PLANNING AMENDMENT

Application No. H16/0002/98

Description: Extension to retail unit

Location: 8 Hall Place
Spalding
Lincs

DATE 30/12/97	SC. 1:5
DRAWING NO. 1122:02	REV.

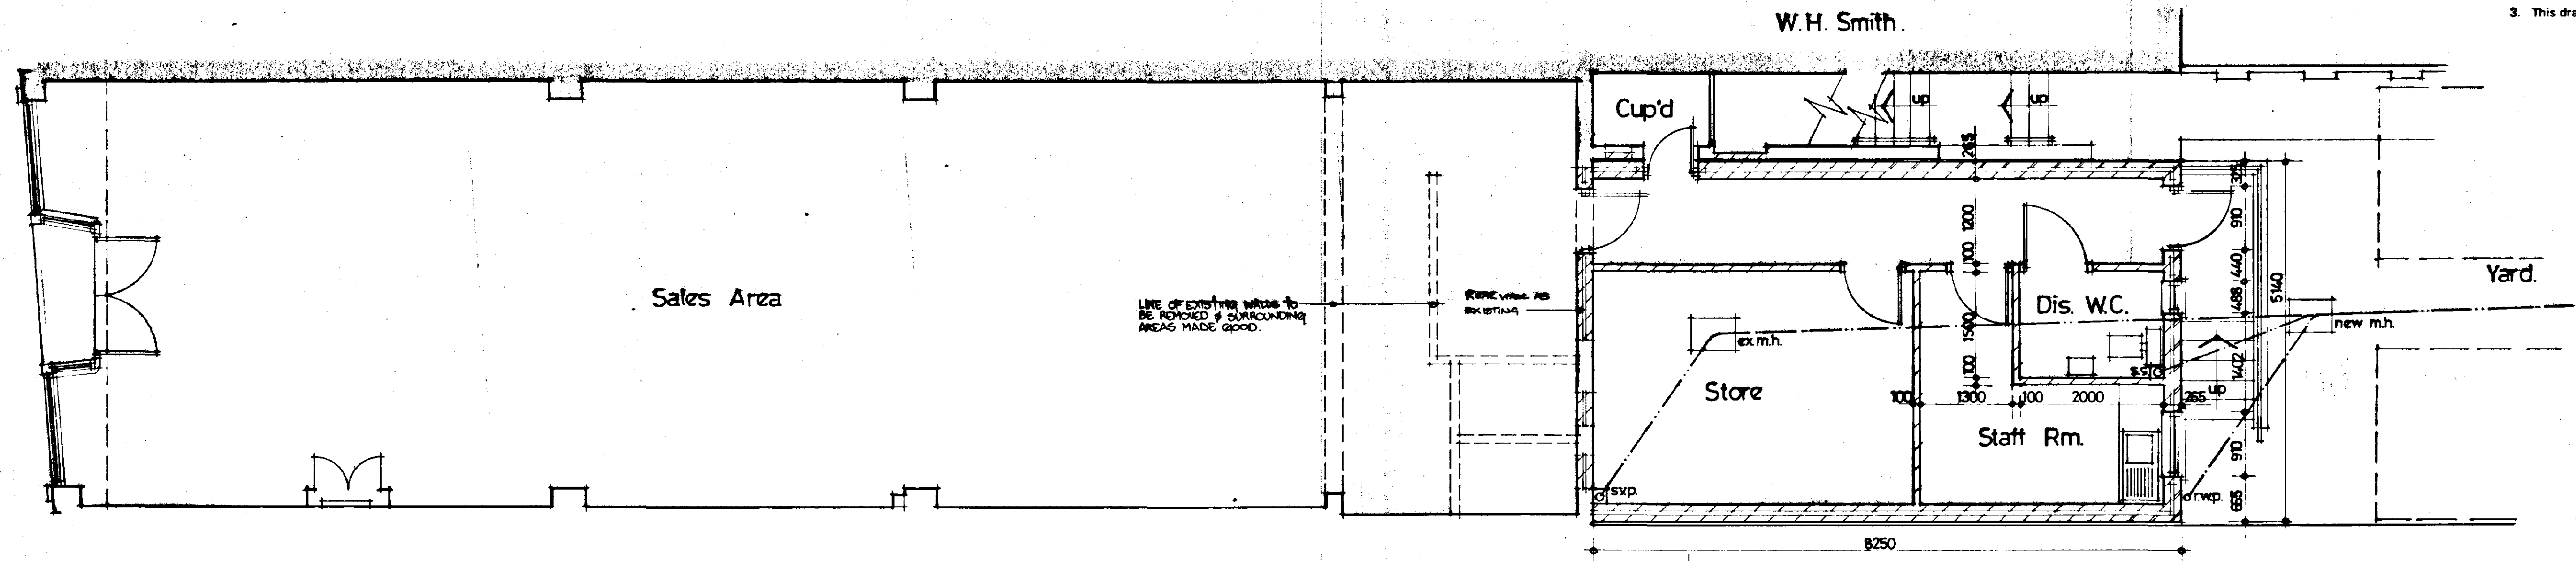
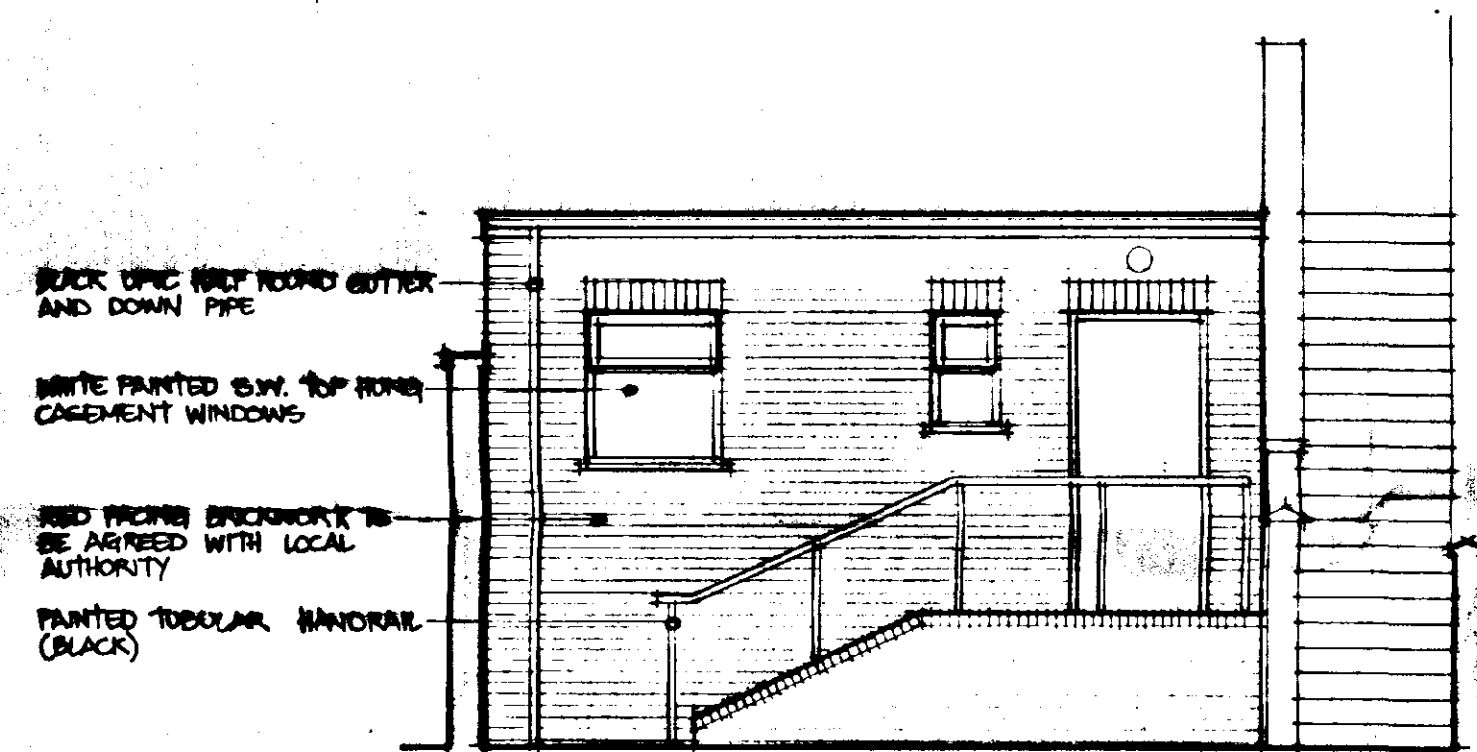
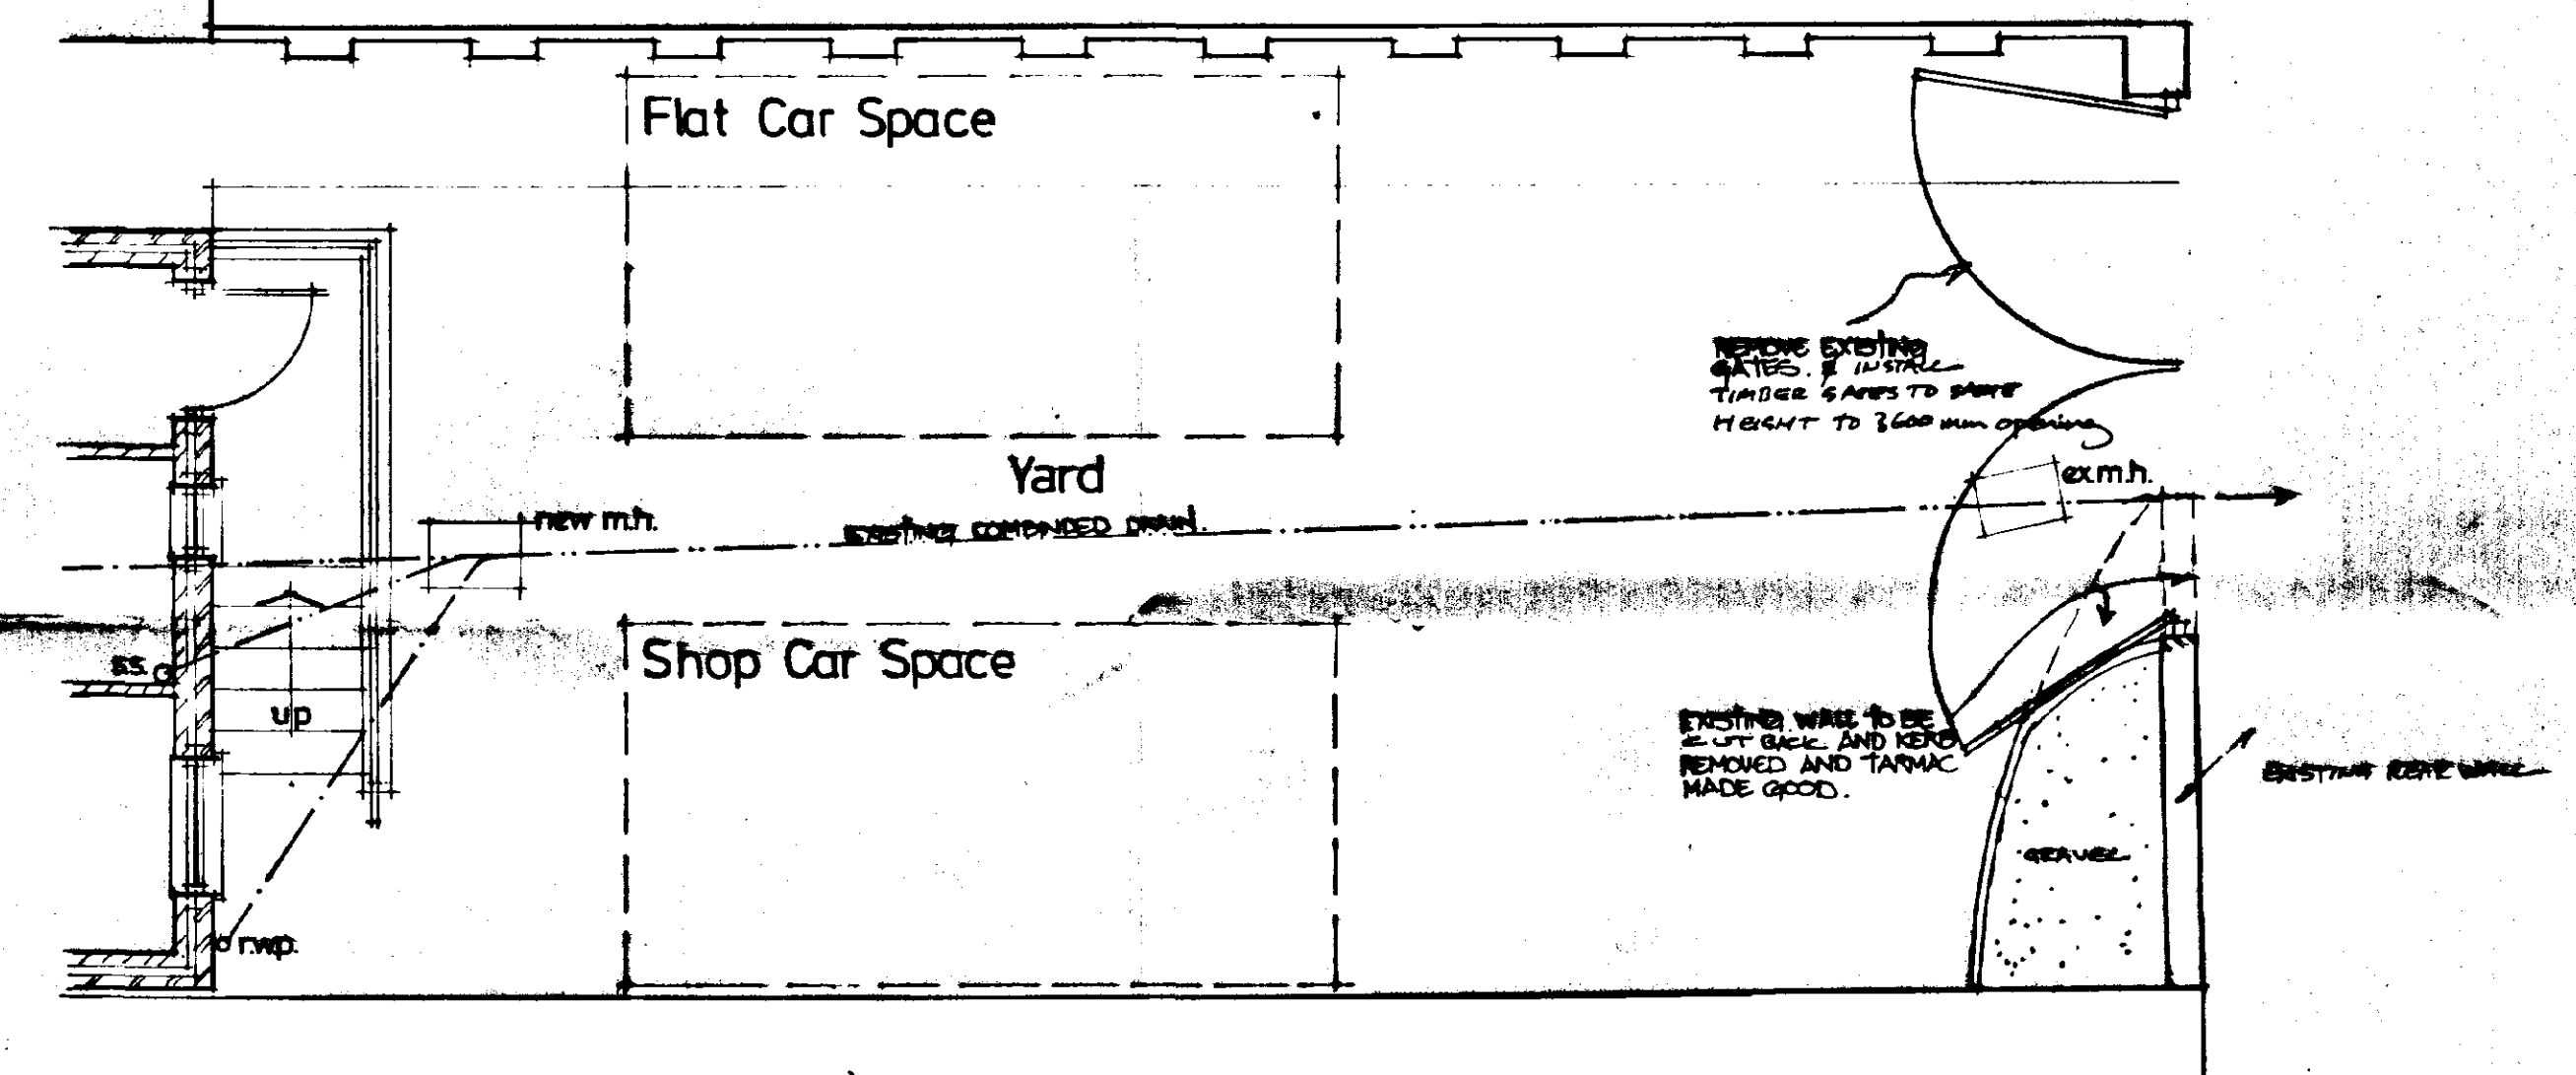
MODIFY EXISTING GATEWAY/REAR
WALL TO GORE LANE IN LIEU
OF DEMOLISHING REAR WALL/
GATEWAY AS PREVIOUSLY PROPOSED.
